Justine Foster
Infrastructure Manager
Planning Services
Lincolnshire County
Council
County Offices
Newland
Lincoln LN1 1YL

Date: 9 February 2026

Application by Beacon Fen Energy Park Limited for an Order granting Development Consent for the Beacon Fen Energy Park Project

This letter sets out Lincolnshire County Council's (LCC) comments on the additional information and submissions received at Deadline 6, LCC's response to EXQ3 and comments on the updated sequential test assessment [REP5-010].

Figure 6.31 Landscape Strategy Plan Part 1 (Change Request)

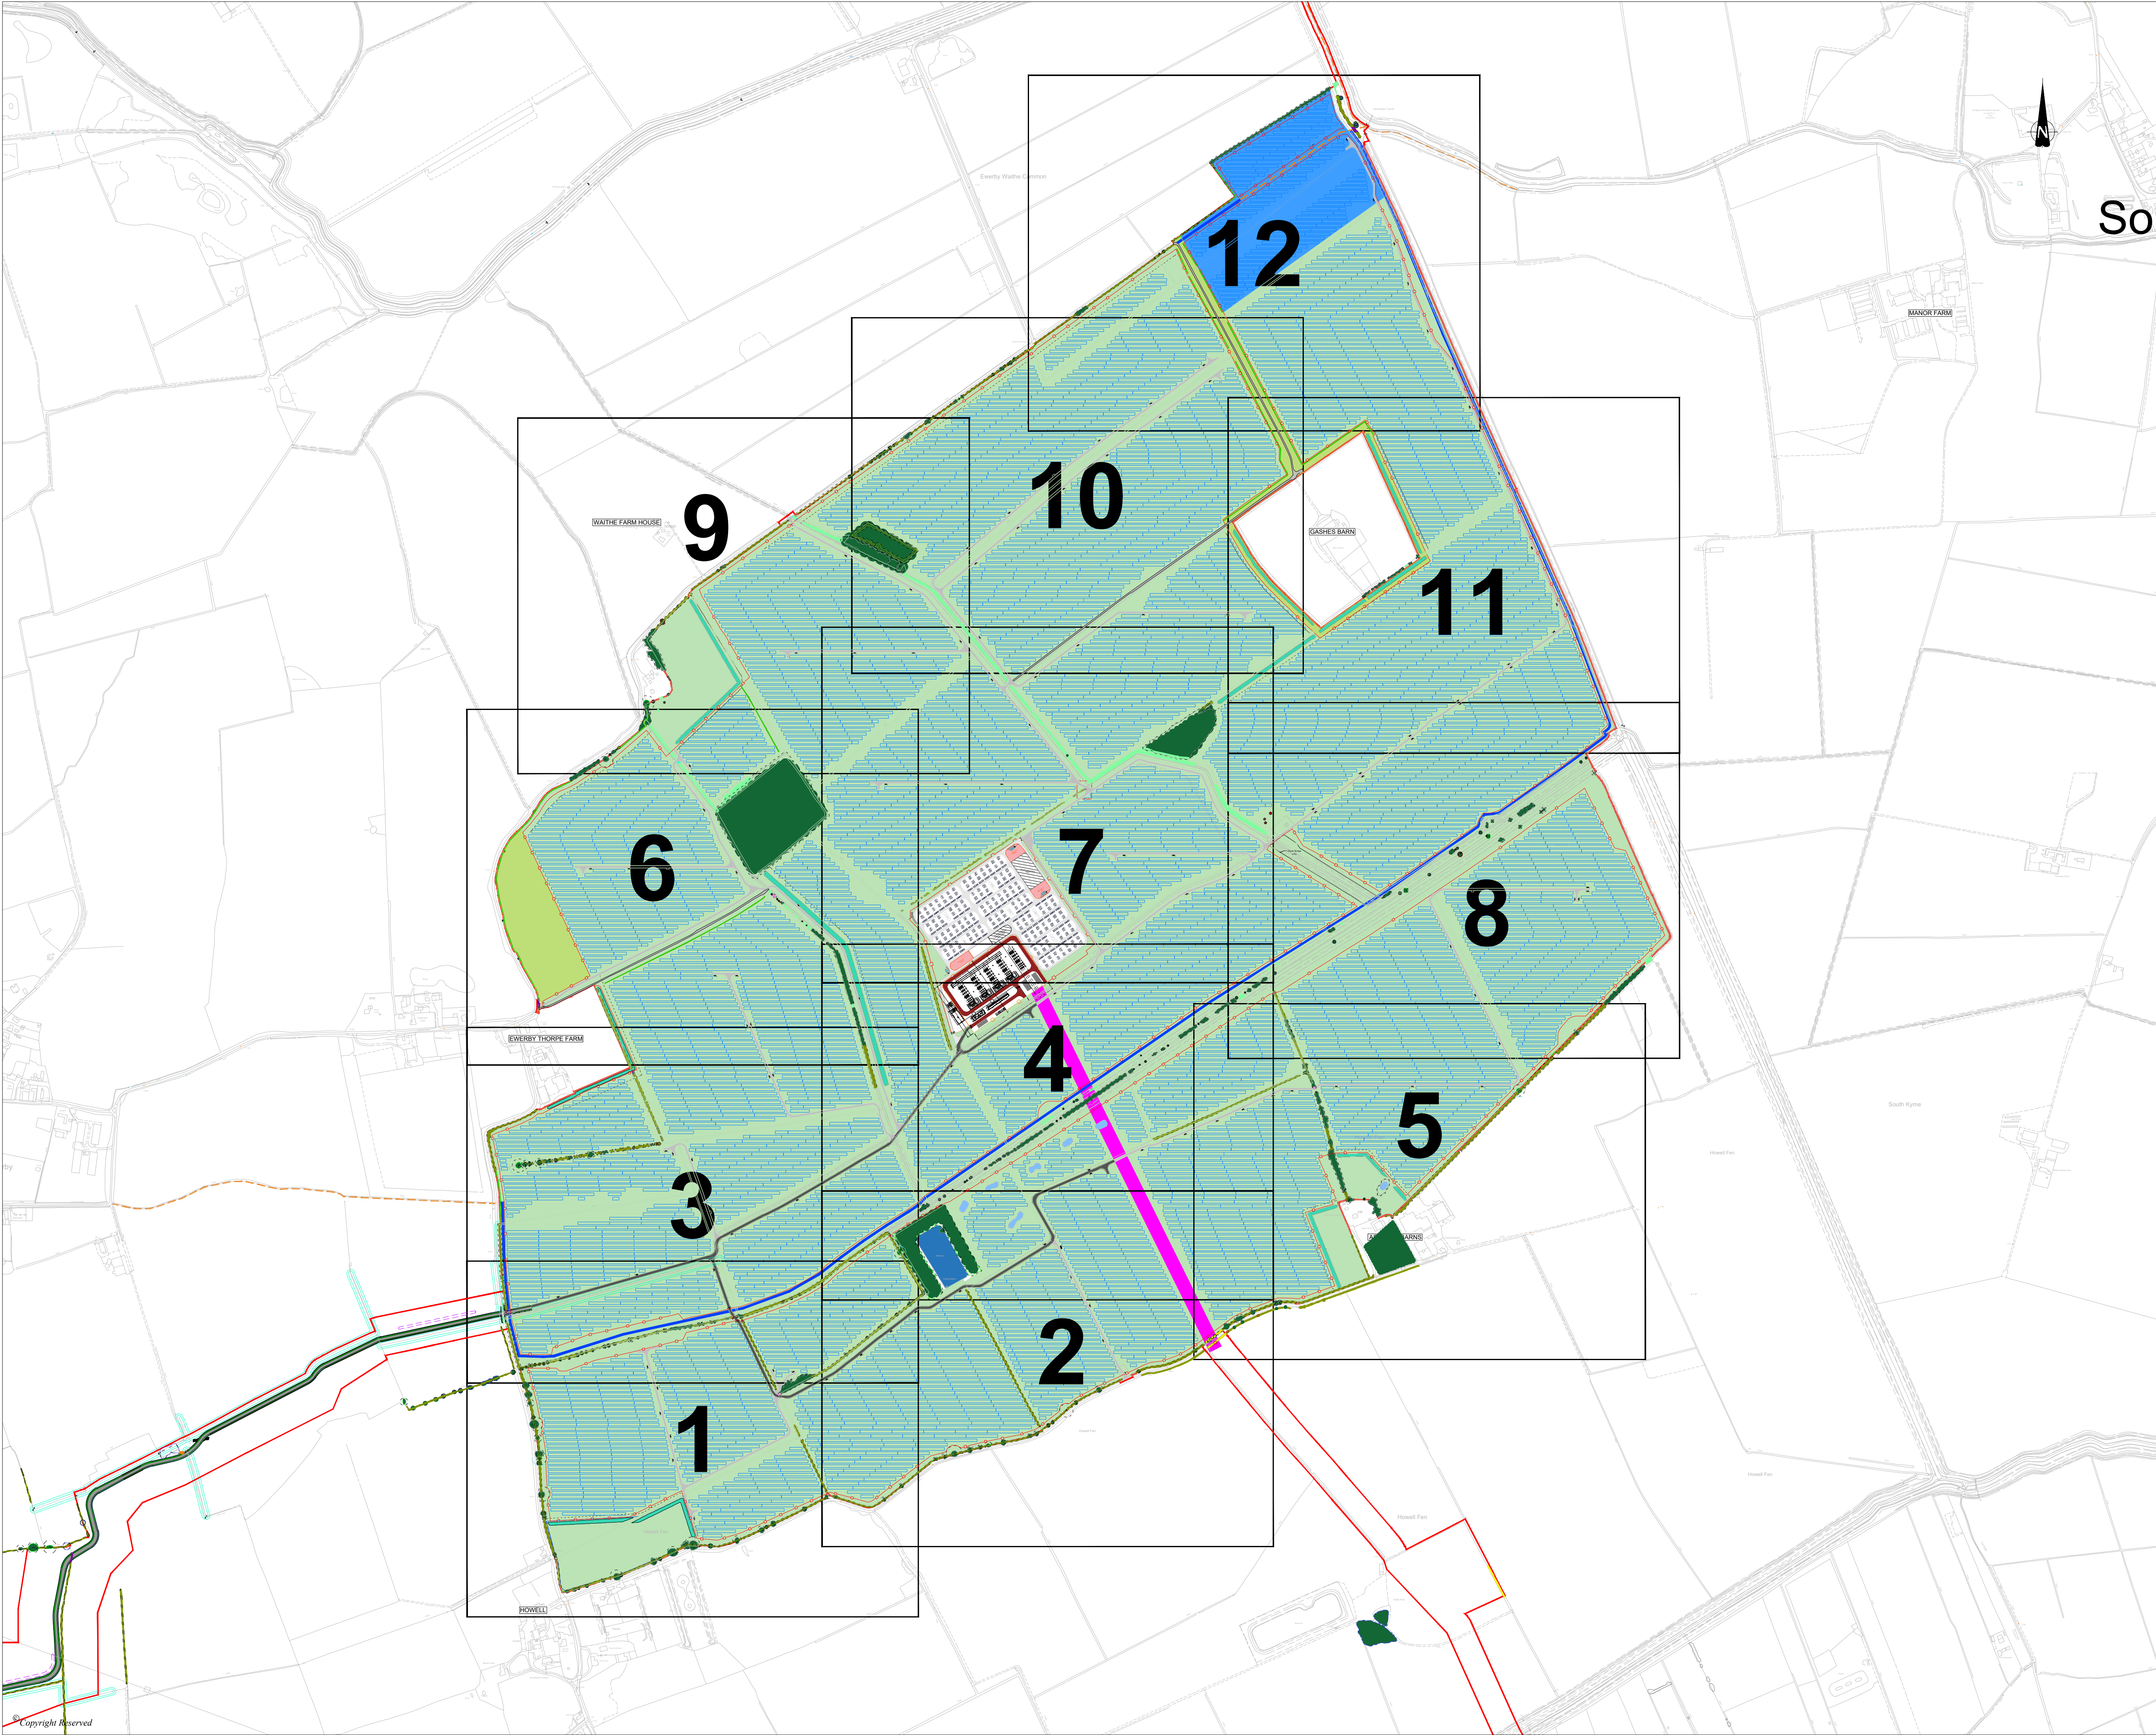
The Council notes the inclusion of information relating to a change request accepted by the Examining Authority (PD-015). The details of the change request include substantial areas of both vegetation removal and establishment. As stated in the Council's Deadline 6 submission (REP6-041), the Council considers that updates to the Applicant's BNG Strategy are required to account for the change.
